October 2, 2015

Project Name: 3-unit condominium building
Project ID: 2015-121
Address: 72 Munjoy Street CBL: 16-B-08 and 09
Applicant: Robert LeBlanc
Planner: Nell Donaldson

3-unit Condominium Development
68-72 Munjoy Street
Level III Site Plan and Subdivision Review
2015-121
Peninsula Property Development

Submitted to: Portland Planning Board Date: September 24, 2015 Public Hearing Date: September 29, 2015	Prepared by: Nell Donaldson, Planner CBLs: 016-B-009 Project #: 2015-121
--	--

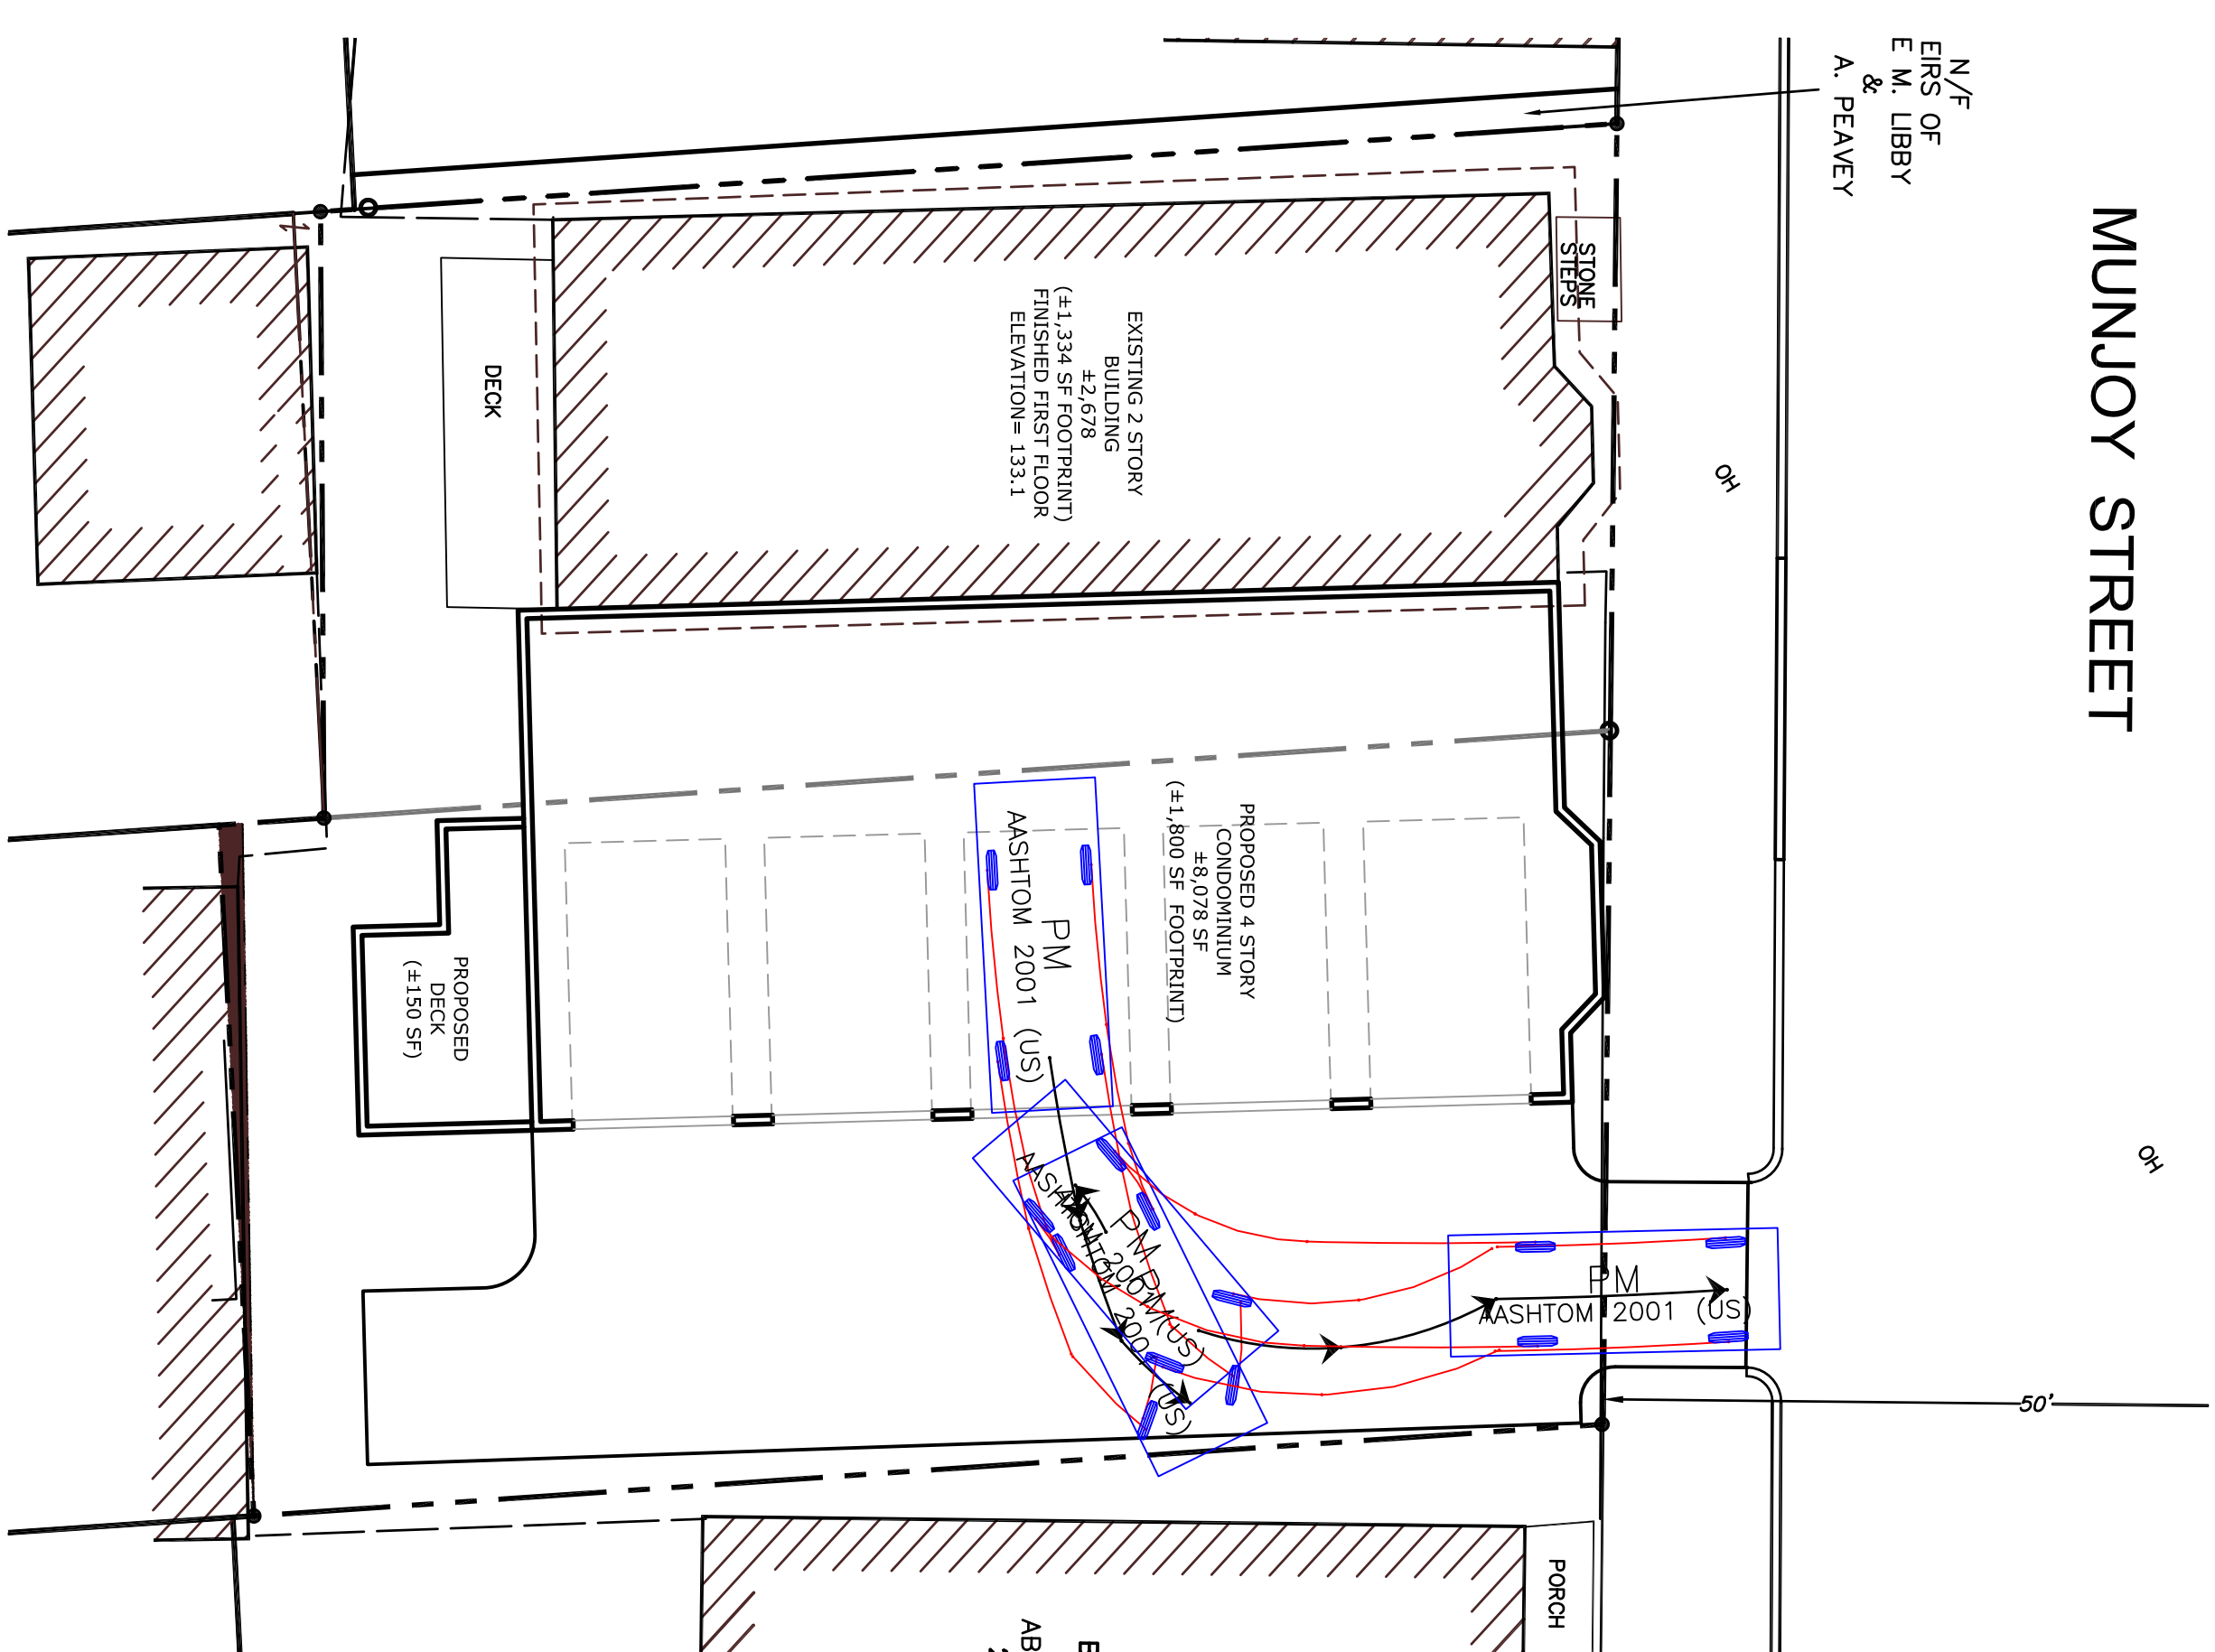
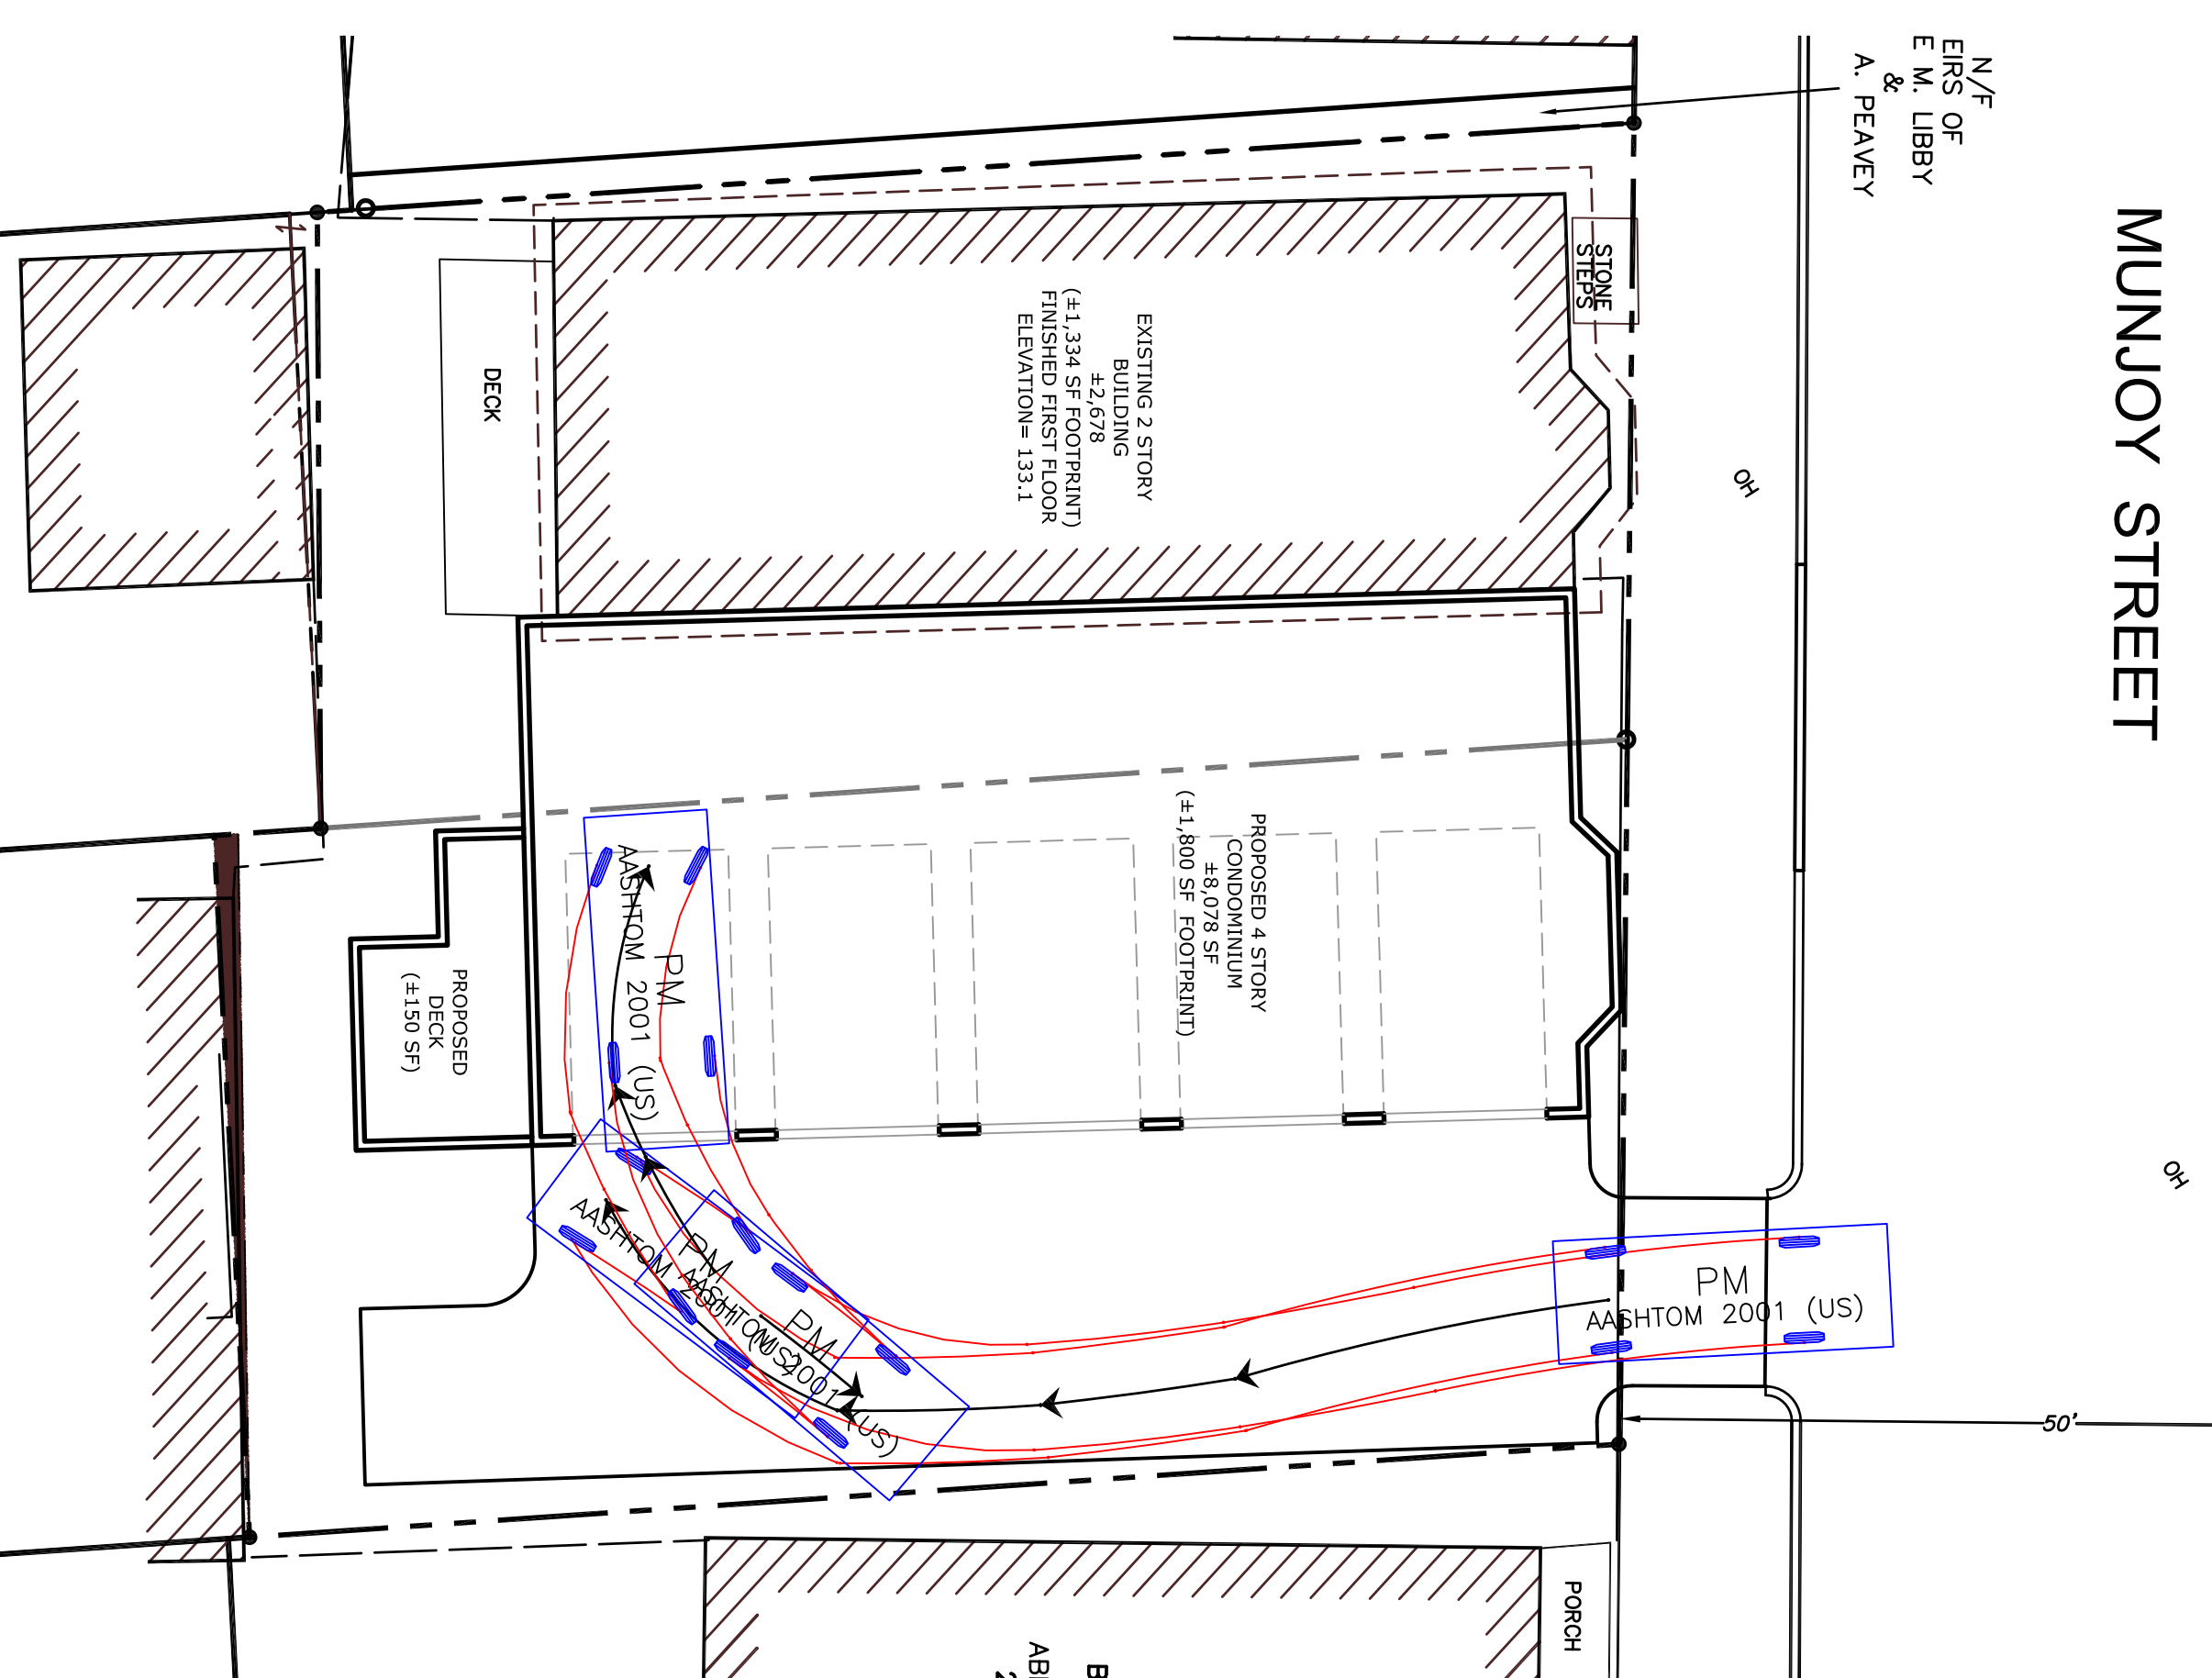
The final plans include the reconstruction of existing brick sidewalk and apron along the frontage of the site. The plans also include a new porous concrete drive aisle which will provide access to five parking spaces within the first floor of the proposed building. The plans show this aisle measuring 18.5' in width and touching the southerly property line at the site's southeast corner. The applicant has provided a turning template which shows that vehicles can maneuver in this area. Mr. Errico writes,

I have reviewed the project site plan and vehicle turning template information and generally find the project to be acceptable. Based upon the vehicle template graphics provided, vehicles will be able to access and egress the parking garages - but with great difficulty. I'm supportive of a waiver on the width of the parking aisle, but the site plan shall be revised to install a barrier that prevents vehicles from encroaching on the abutting property. One suggestion would be a wooden guide rail.

1. Prior to the issuance of a certificate of occupancy, the applicant shall submit plans to eliminate the potential for vehicular encroachment on the adjacent property for review and approval by the city's consulting traffic engineer;
2. The applicant shall provide a revised landscaping plan including:
 - a. Plant quantities, sizes, and locations;
 - b. Details regarding the supporting structure for the proposed climbing hydrangea; and
 - c. Notes which state measures to be taken to protect street trees during construction for review and approval by the city's arborist; and
3. The applicant shall revise the plans to depict underground electrical service for review and approval by the Department of Public Services.

The applicant has engaged the adjacent neighbor in an effort to come to an agreement on the treatment of this property line. Resolution of this matter has been included as a condition of approval.
